**Consultation Response from KC,
 Policy**
2020/92331 Land east of, Leeds Road, Chidswell, Shaw Cross, Dewsbury

Outline planning application for demolition of existing dwellings and development of phased, mixed use scheme comprising residential development (up to 1,354 dwellings), employment development (up to 35 hectares of B1(part a and c), B2, B8 uses), residential institution (C2) development (up to 1 hectare), a local centre (comprising A1/A2/A3/A4/A5/D1/D2 uses), a 2 form entry primary school including early years provision, green space, access and other associated infrastructure

Date Responded: 29
 September 2020

Responding Officer: Hannah
 Morrison

Figure 4-1 Illustrative Masterplan

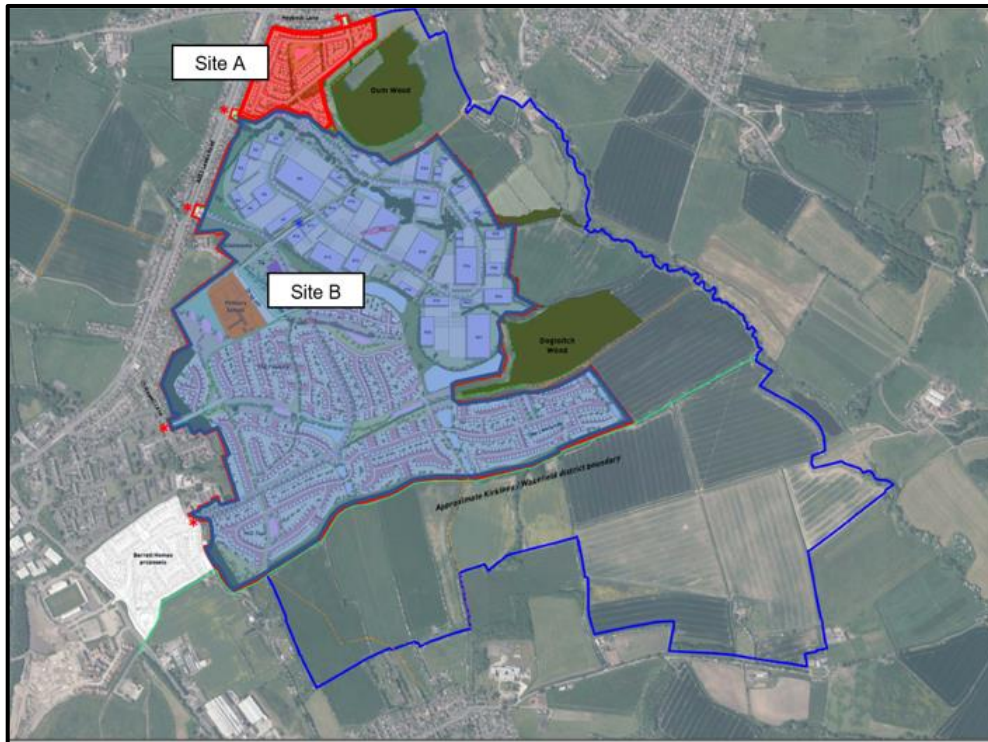
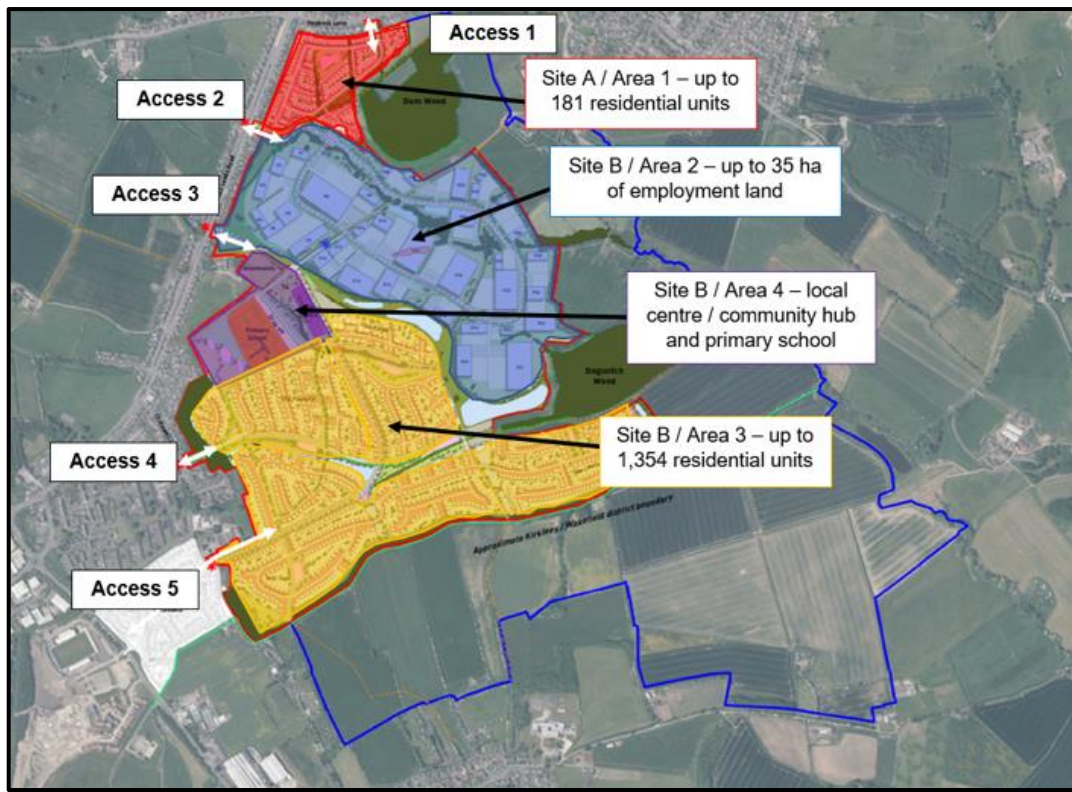
The planning application is accompanied by a masterplan framework, as set out in site-specific considerations, the with the masterplan set out on page 44. There are some concerns with the layout in terms of the interaction between the POS / play areas and homes, e.g. the play area at Hill Top to SW of site layout appears to be at the backs of houses. The site layout should have regard to LP24 criteria e and g in respect of the POS layout. In the elevated SW of the site, attention should be paid to the interaction of the site with the wider landscape, in terms of screening etc in accordance with policy LP32. There is also the need to ensure that the site allows for the site layout to be walkable and to meet the user hierarchy as set out in the Highway Design Guide SPD and Local Plan policies LP20 and LP24.

Whilst these issues are more detailed, the access to the site may have some bearing on them and more detailed design work that can be undertaken at reserved matters stage.
